**Recommendation:** Approve

**Applicant:** Heyford Park Developments Ltd

**Proposal:** Partial discharge of condition 8 (landscaping scheme) (Relates to Phase 10 only) of 18/00825/HYBRID

Description:
Landscape Proposals Plan - Sheet 2 of 2

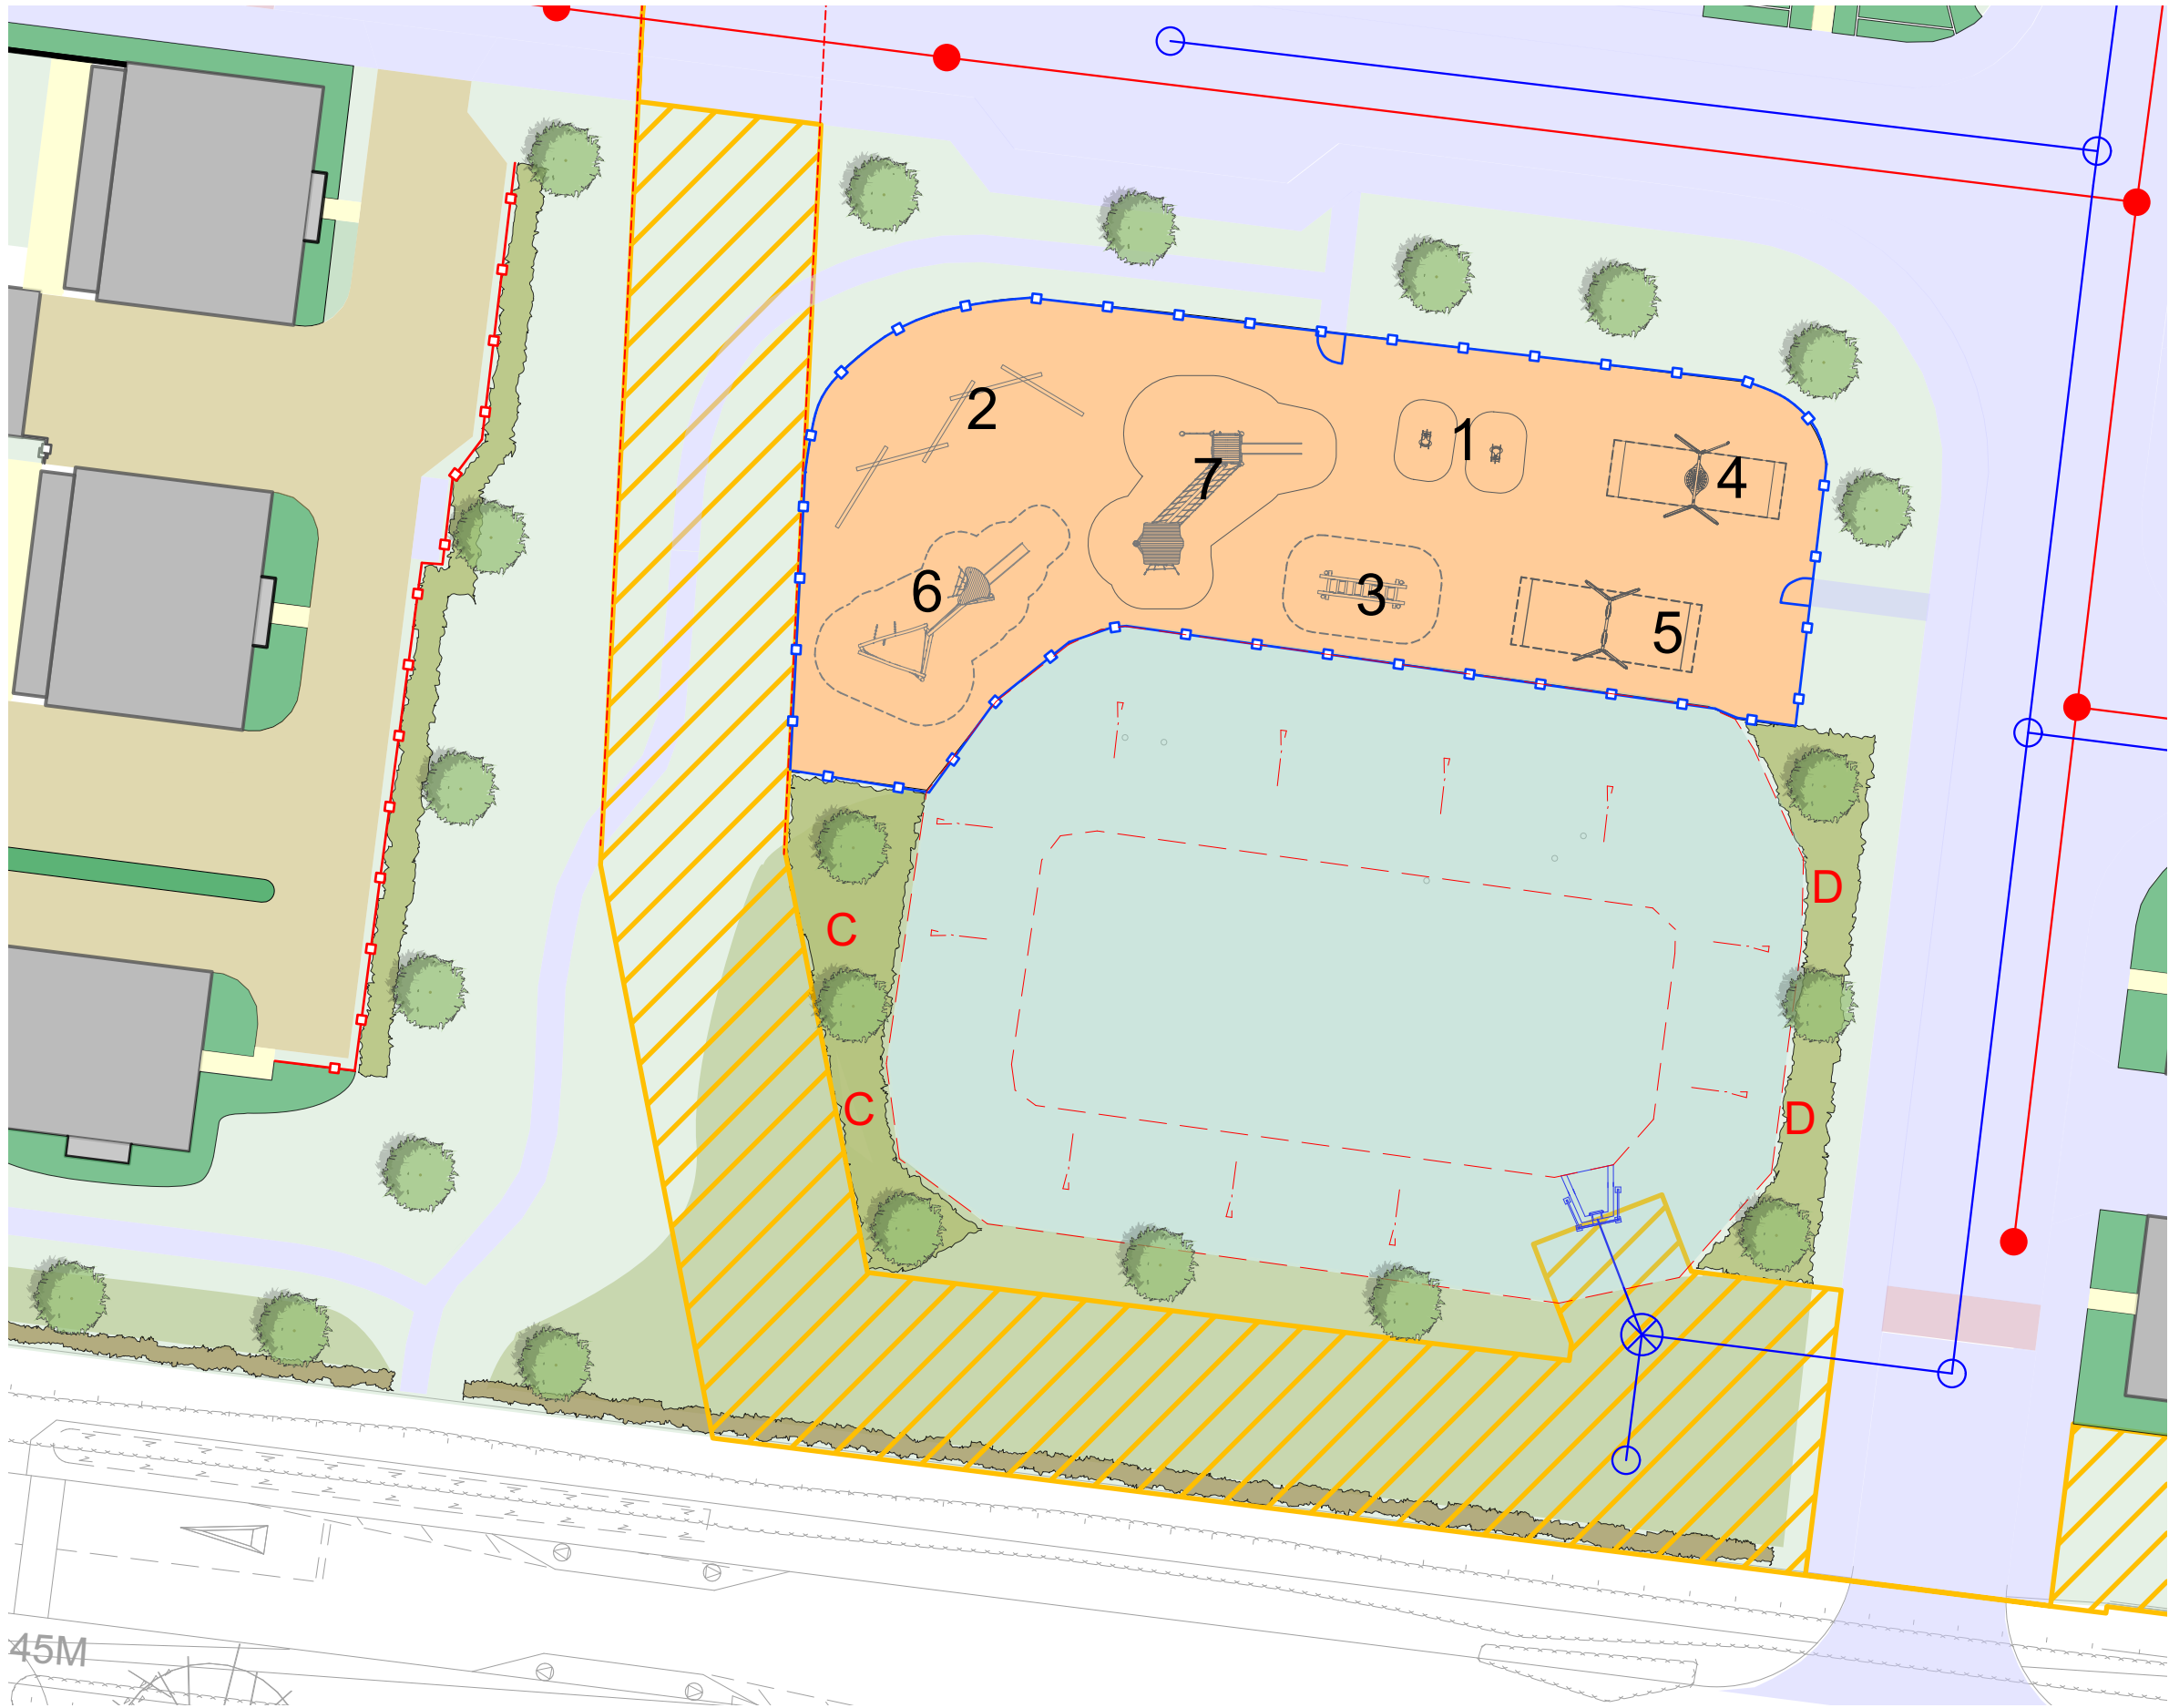
*'A scaled-up A3 plan of the play area is required to show the appropriate level of detail to indicate the position of seats (with arm and back rests), litter bins, dog exclusion signage, signage (with ManCo contact details). Please note that signs must not be secured to gates or fencing because this is a hazard to children (opening gates and figure entrapments and sharp edges). A third access for pedestrian and maintenance is required (in case play equipment needs to be replaced etc). The entrance will require a double gate where one leaf is secured with a padlock and the other a self-closing pedestrian gate. This access should be located on the western boundary to allow another means of escaping from an enclosure if children feel threatened in some way.*

*Construction details of the wet pour safer surfaces and macadam paths with pin kerb retaining edges are necessary to ensure robust construction methods are followed.*

*'22/02695/DISC:- Tree Planting Plan Soil Volumes - Sheet 1 of 2 & Sheet 2 of 2 Dwg. No. LAS 242 05 B are acceptable.  
Landscape Proposals Plan Sheet 1 of 2 & sheet 2 of 2 Dwg No. LAS 242 03 F are also acceptable.'*
